OFFICIAL NOTIFICATION OF DECISION

Project# PR-2022-006673
Application#
SD-2024-00123 PRELIMINARY/FINAL PLAT

**TRACT 1-A, BLOCK 101, BRENTWOOD
HILLS SUBD** zoned **MX-M**, located at **2600
JUAN TABO BLVD NE** containing
approximately **1.8004** acre(s). **(H-22)**

PR-2022-006673 August 28th, 2024 Notice of Decision

Sidewalk Exhibit For
 Tract 1-A, Block 101
Brentwood Hills Subdivision
 Section 10, Township 10 North, Range 4 East, N.M.P.M.
 Albuquerque, Bernalillo County, New Mexico
 June, 2023

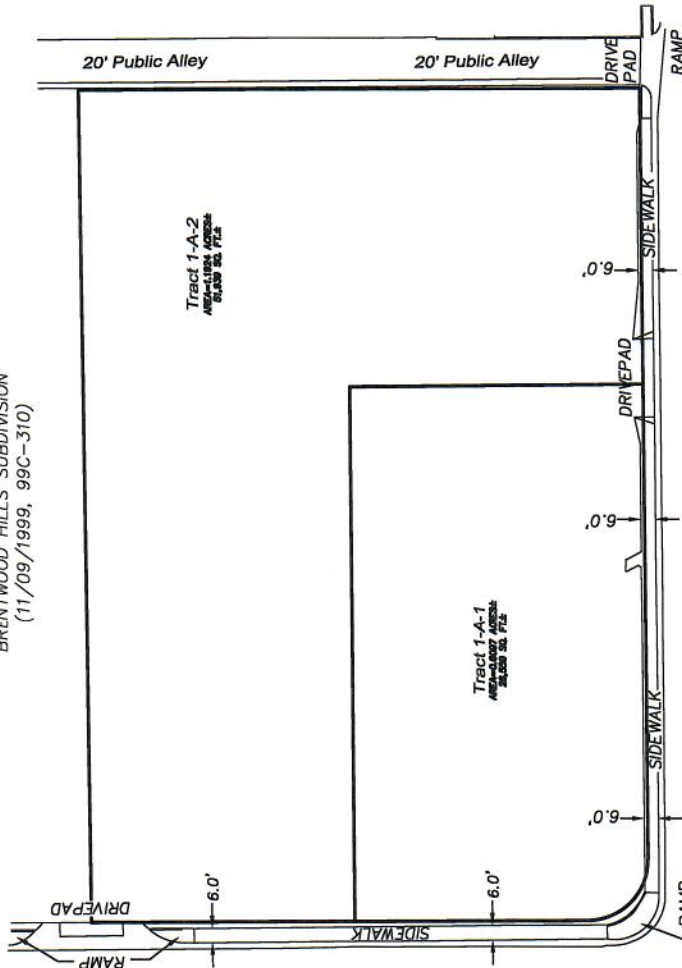
- a) Add Cross Lot Drainage Easement note specifying the beneficiary and maintenance agreement.
- b) Provide 4' clearance around obstacles in the sidewalk (light-pole and fire hydrant appear to encroach).
- c) Add Project and Application numbers must be added to the Plat.
- d) Provide a copy of the AGIS-approved DXF file.
- e) Add the date of the DHO approval to the Plat.
